Application no: H06/1220/99

Applicant: S E King Building Contractor
192 Bridge Farm
New Road
Sutton Bridge
Spalding Lincs PE12 9QE
Description: Erection of chalet bungalow
and garage

Location: Plot adj. Chapel House
Main Street
Gedney Dyke
Spalding Lincs

ACKNOWLEDGEMENT OF AMENDMENT

FIRST FLOOR PLAN

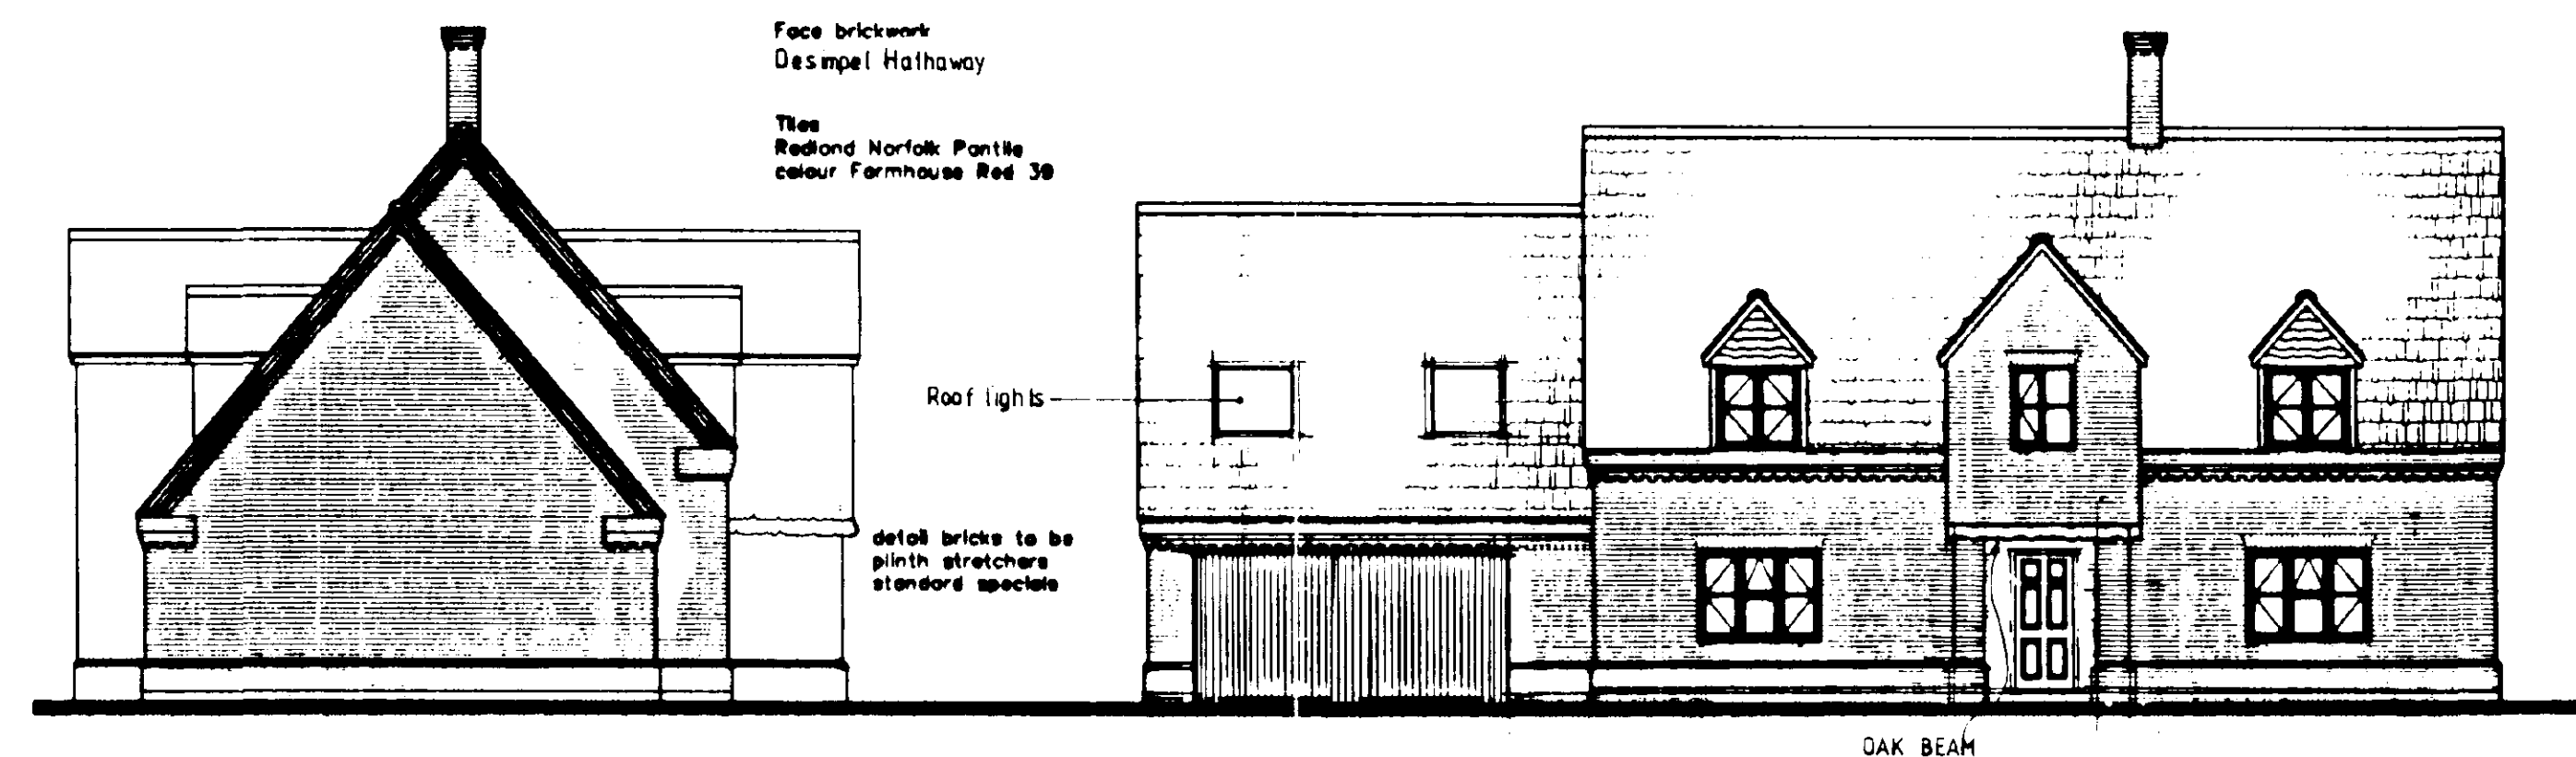
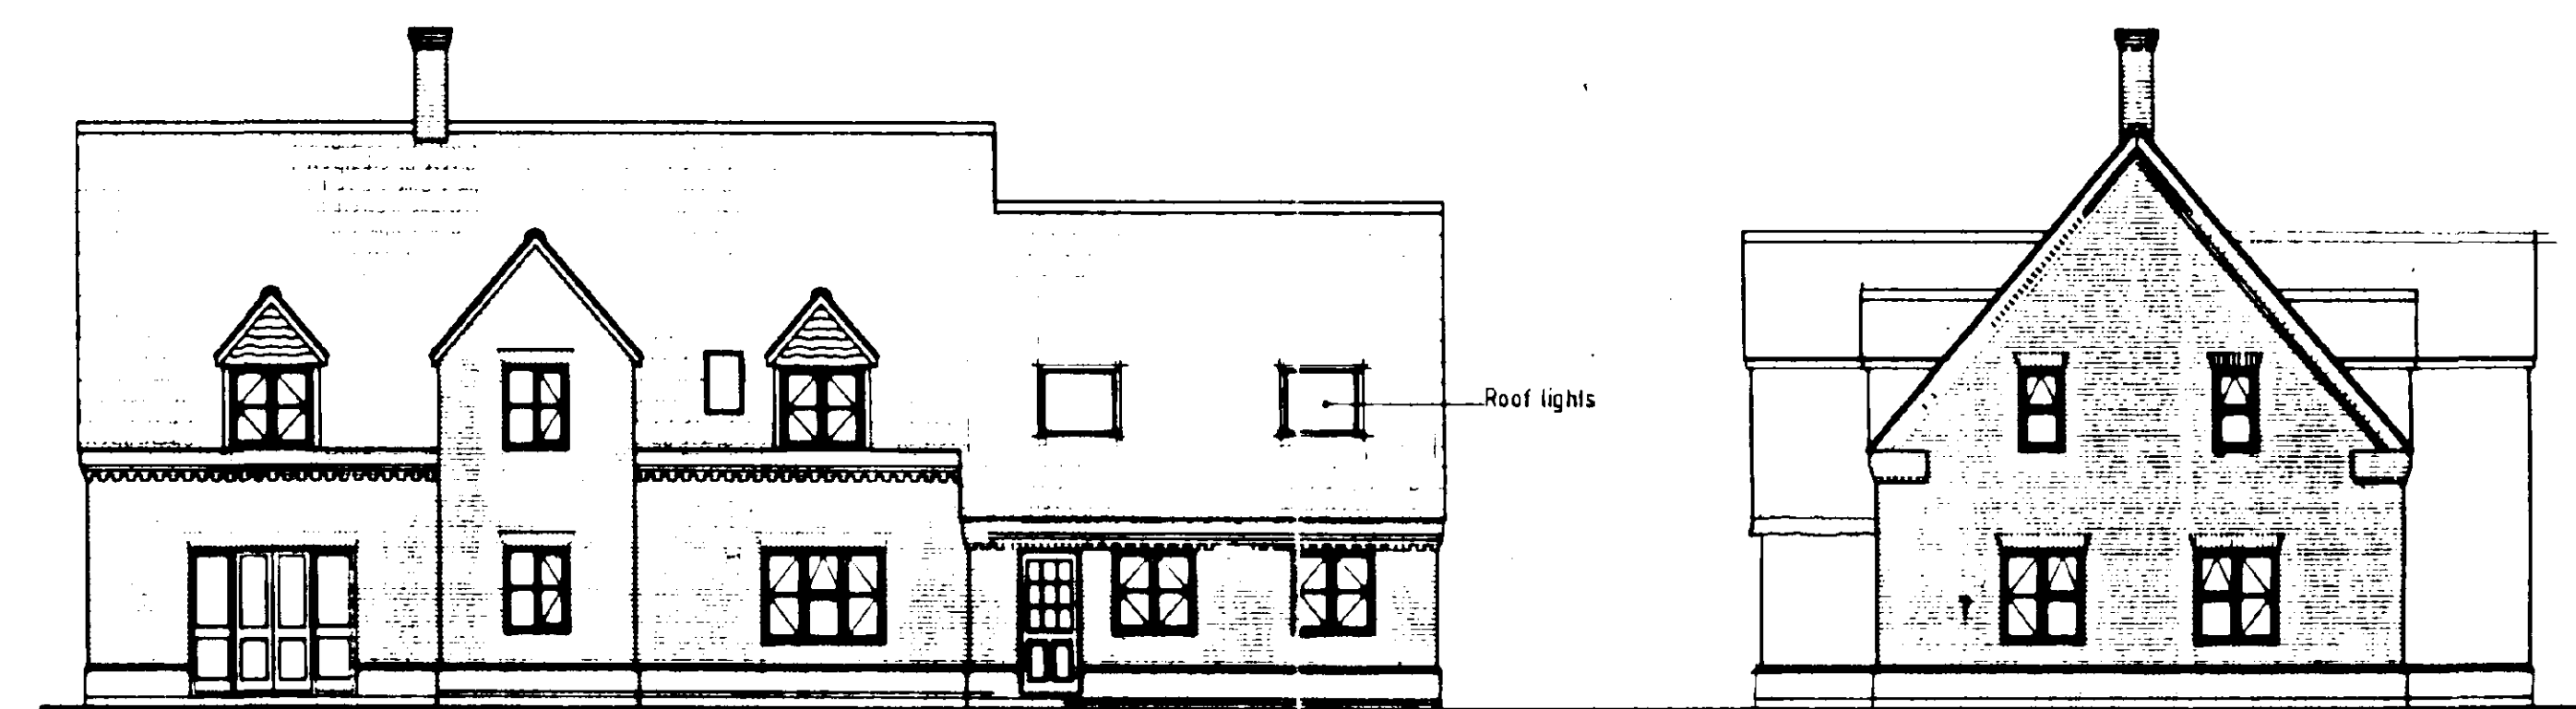
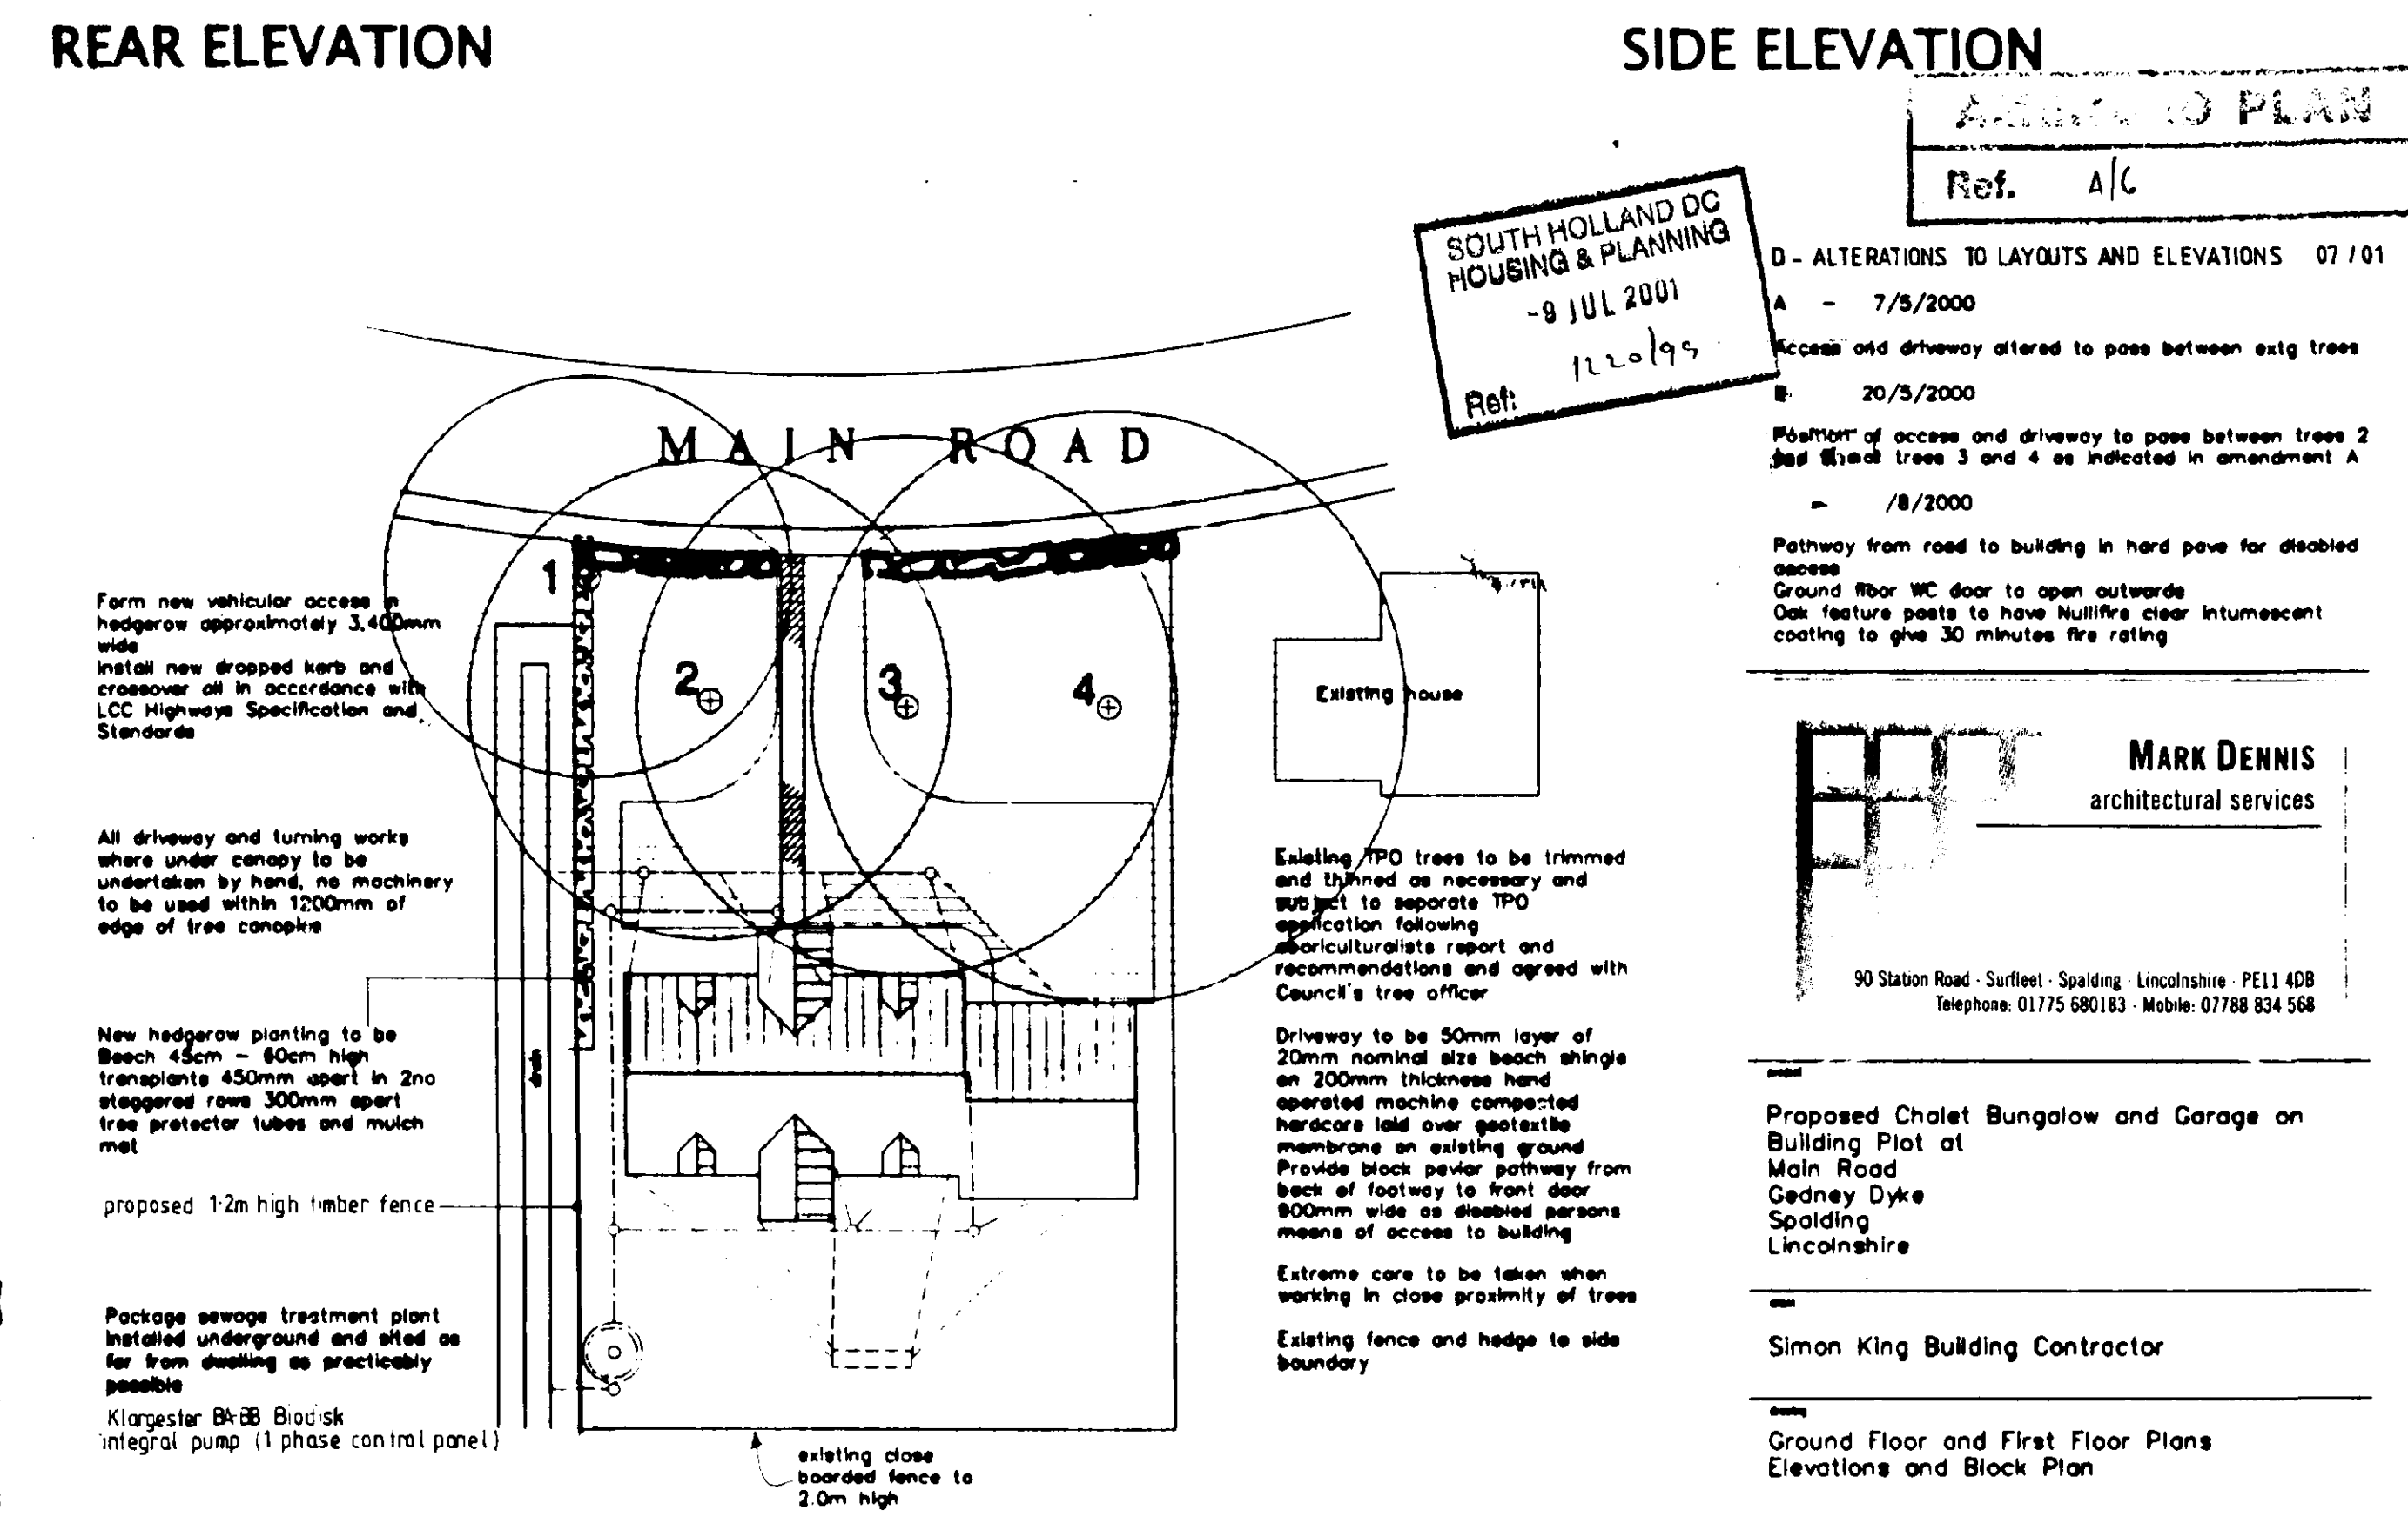
Amendment: Room over garage and roof lights added. Alterations
to front lobby area and garage door. (dwg no. 05D)

ROOM INCORPORATED OVER GARAGE,
ROOF LIGHTS PROPOSED TO FRONT & REAR
MINOR ALTERATIONS TO FRONT PROJECTION
(LOBBY AREA).
GARAGE DOOR REUSED.

The amended details submitted in respect of the above proposal have been received and I consider that the changes are too significant to be treated merely as a amendment. A fresh application will therefore be required (forms enclosed). This does not imply that premission will or will not be forthcoming for any such revised application.
